Current Zoning: MX-1 (mixed use district)  
Proposed Zoning: N2-A(CD) (neighborhood 2-A, conditional)

Approximately 33.95 acres located east of Bending Branch Road and west of Interstate 485, north of Albemarle Road.

The petition proposes to allow a 124-unit single family attached (townhome) residential community on vacant acreage previously approved to allow 75 single family detached homes.

**SHEET**  
**REZONING PLAN**  
**RZ.01**

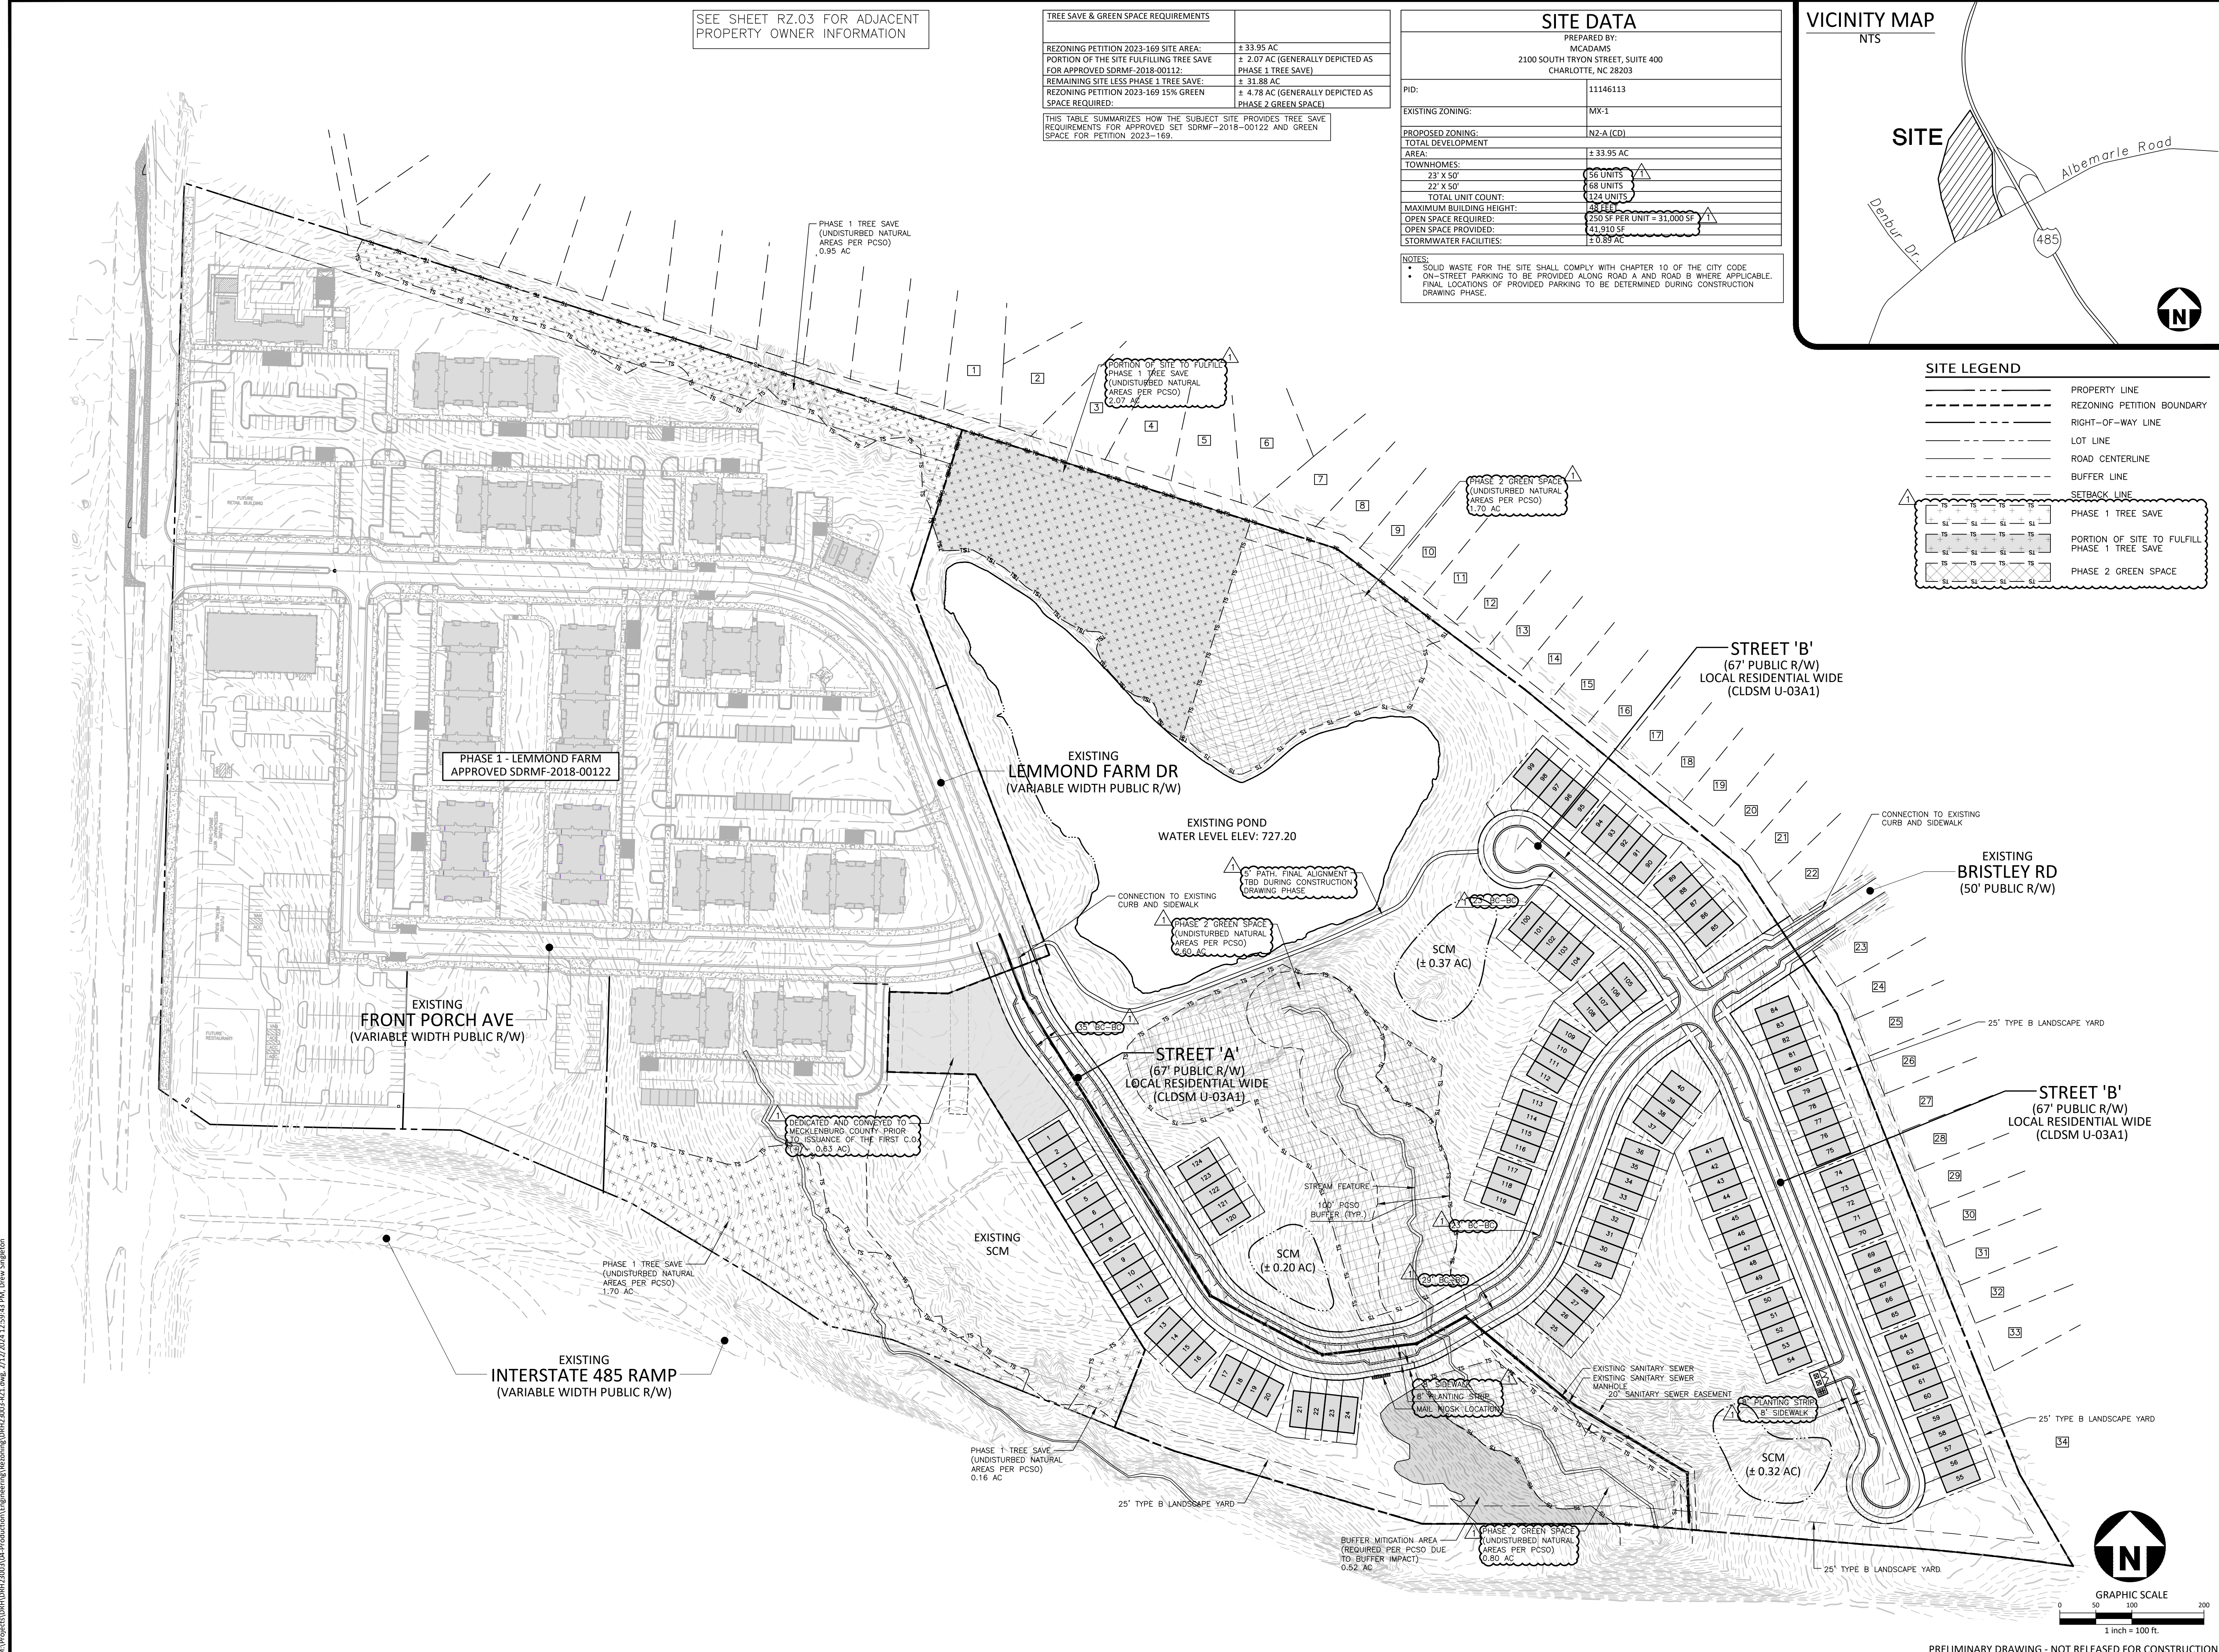
- ~~3. Please confirm with Zoning Administration if an administrative amendment is required as part of the process. **Rescinded**~~
- ~~4. Label setback along Public Streets A and B.~~
- ~~5. Label zoning of abutting parcels, including next door NS zoning.~~
- ~~6. Note 1.d. limits the total number of buildings to 28, but 26 buildings are shown. Please revise so the graphic depiction of the plan matches the notes.~~
- ~~7. Please modify Note 4.b. to refer to "landscape yard".~~

- ~~8. Tree save does not appear to meet the referenced site plan.~~
- ~~9. Tree save has already been established. Green space location has already been determined per the previous plans.~~

RZ.02

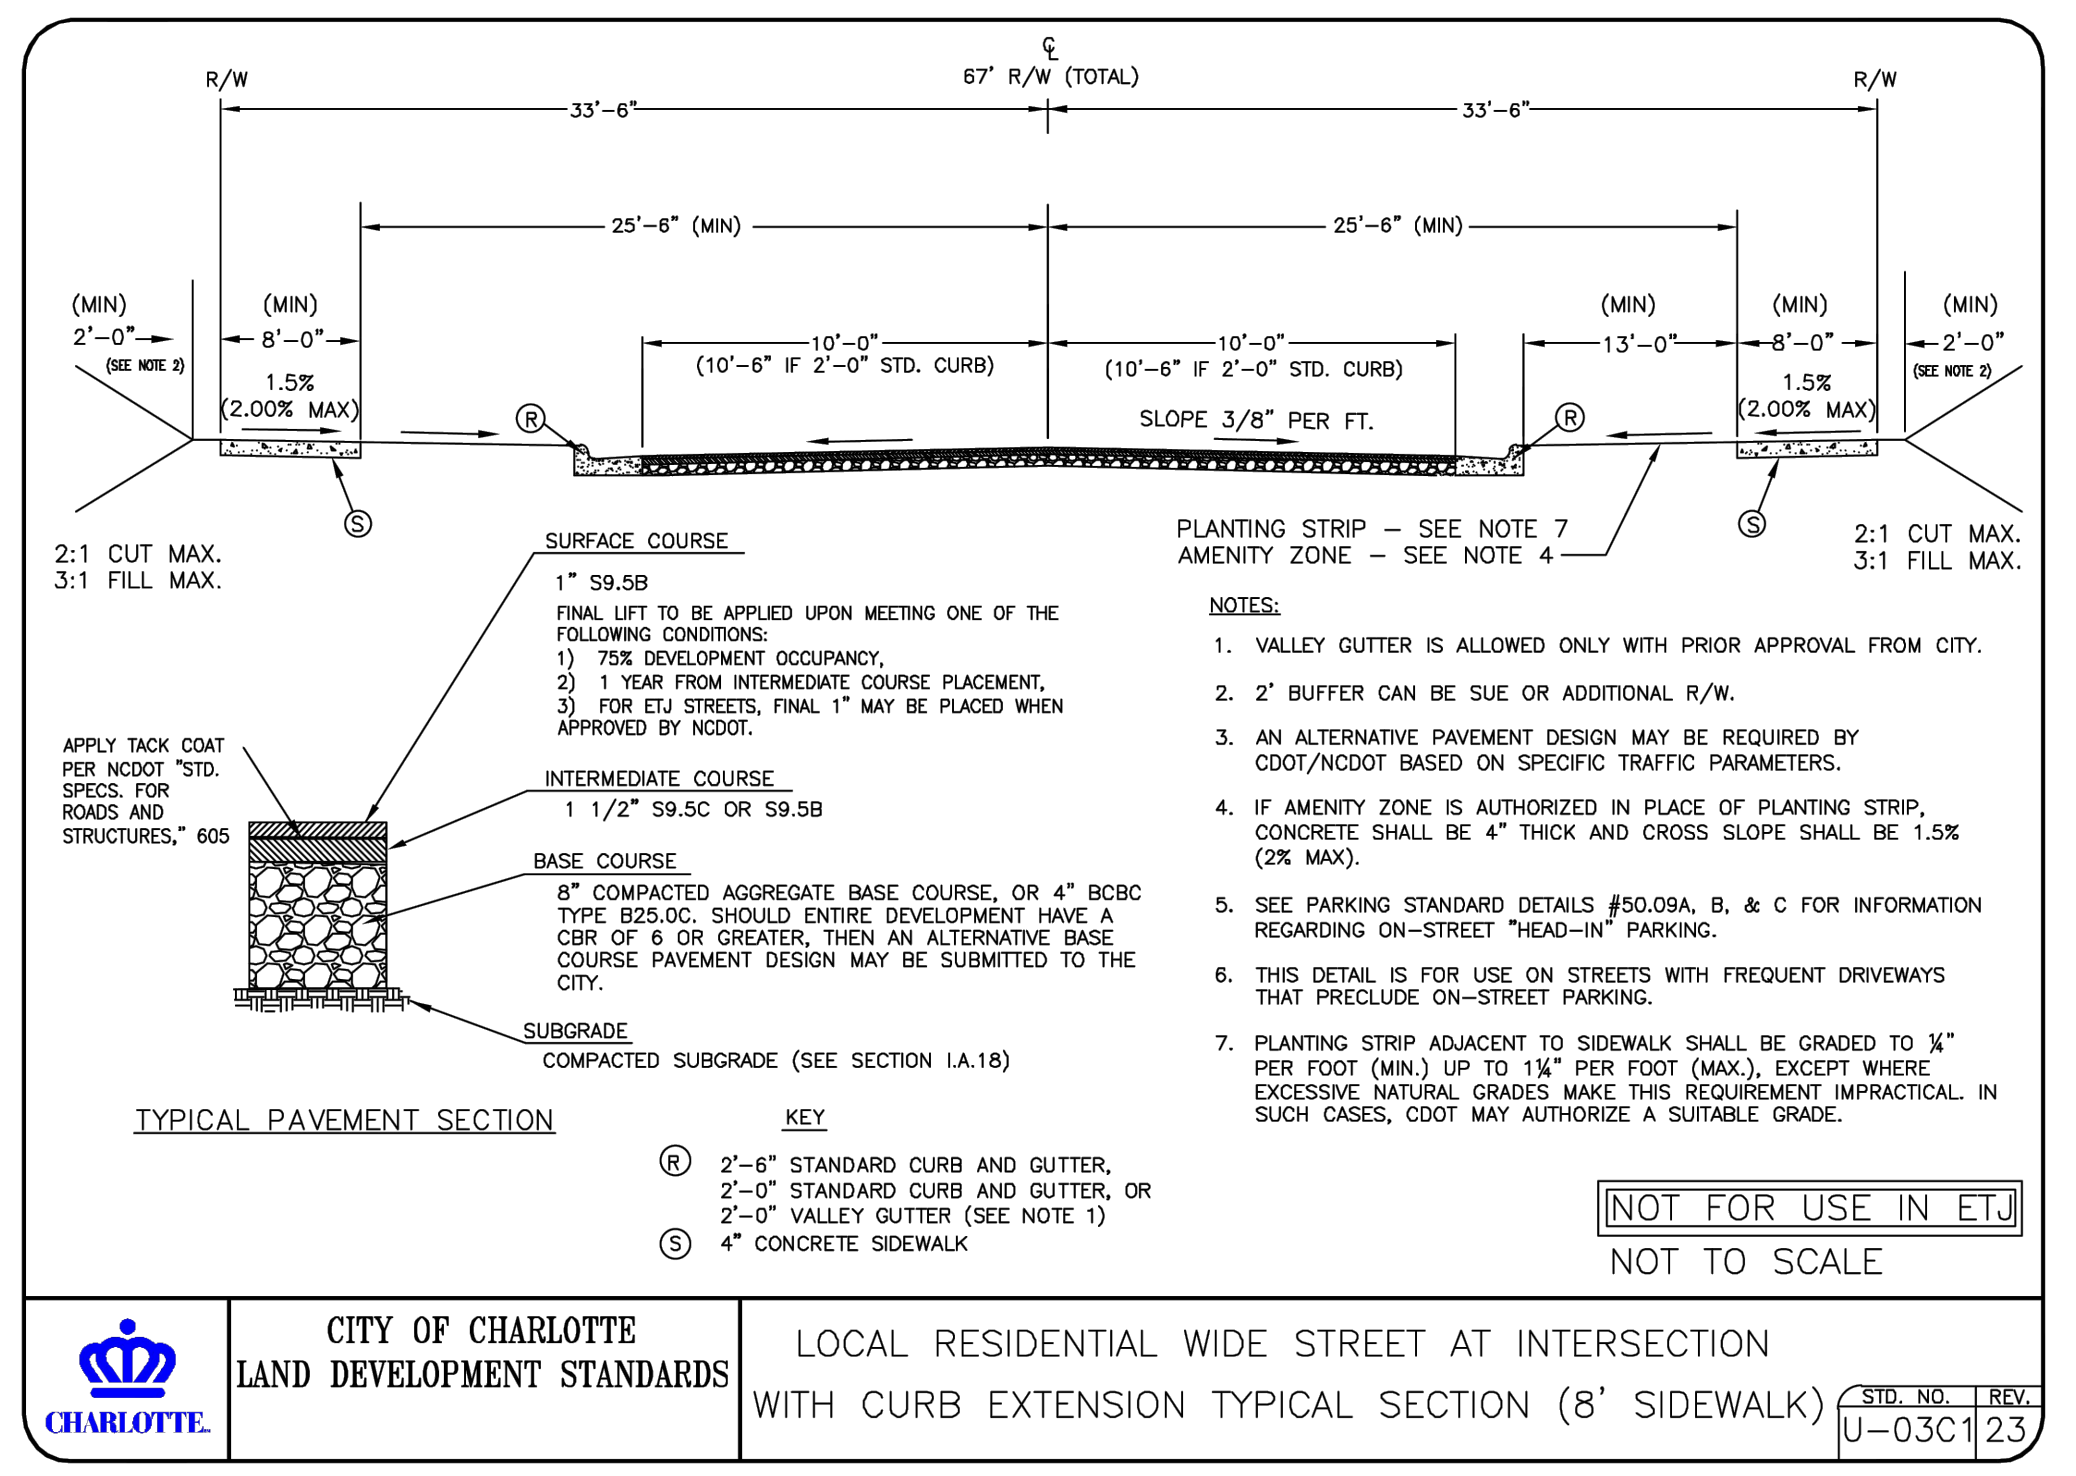
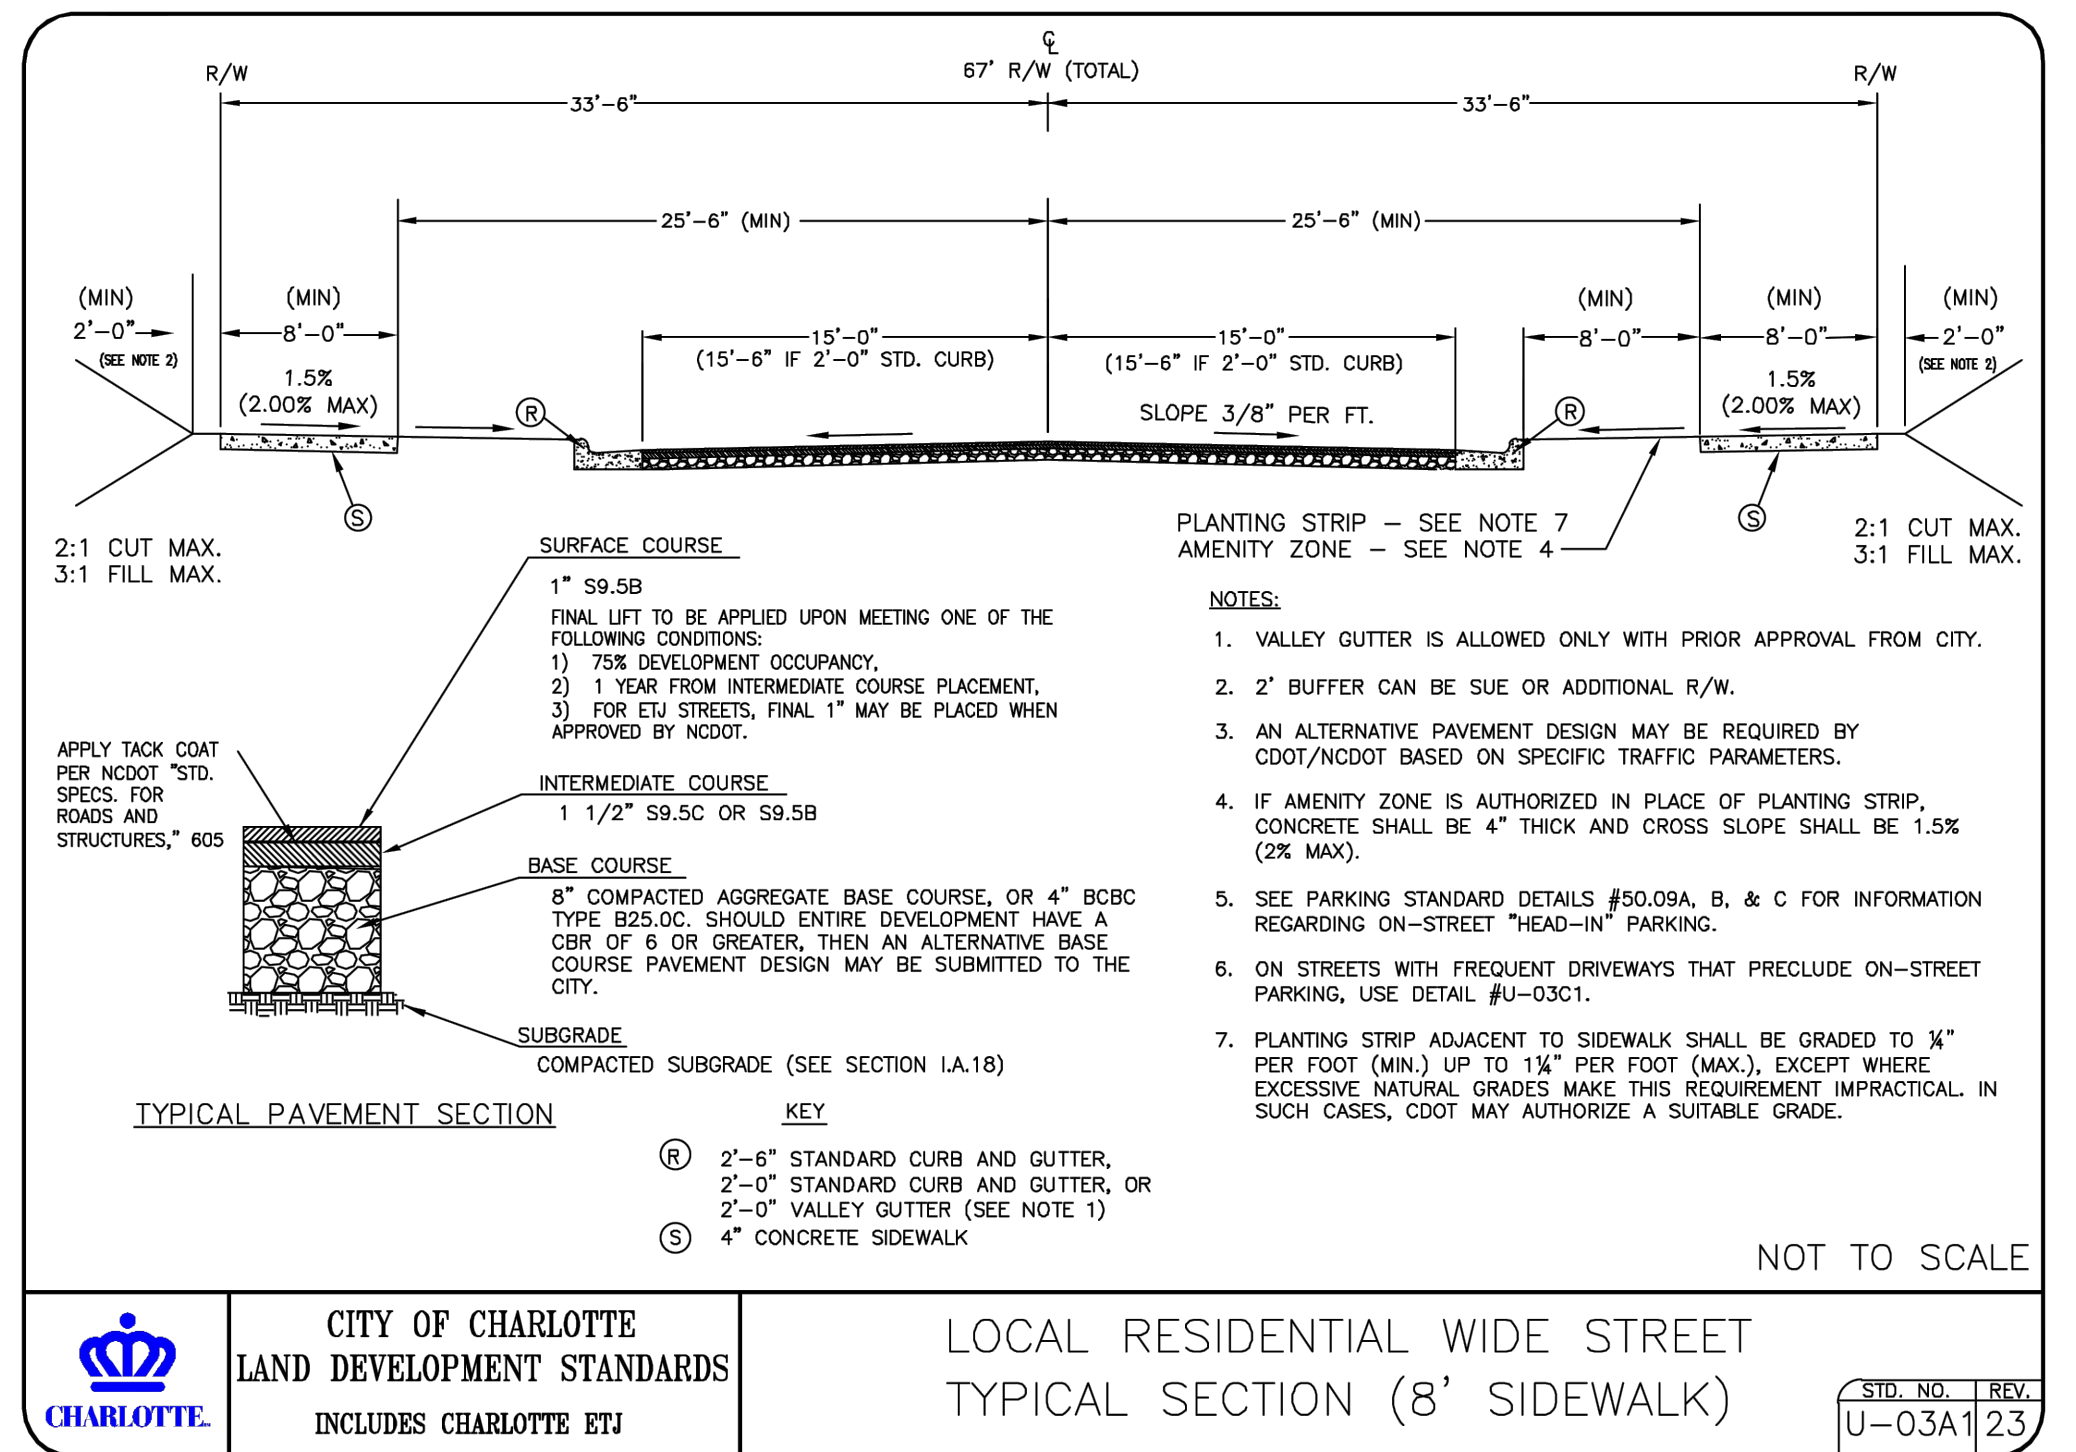
- ~~10. Please revise 6.c. to read per the standard note: Development within any SWIM/PCSO Buffer shall be coordinated with and subject to approval by Charlotte Mecklenburg Storm Water Services and mitigated if required by City ordinance. Stream Delineation Reports are subject to review and approval by Charlotte Storm Water Services. Need to remove RZ.02 from the note.~~
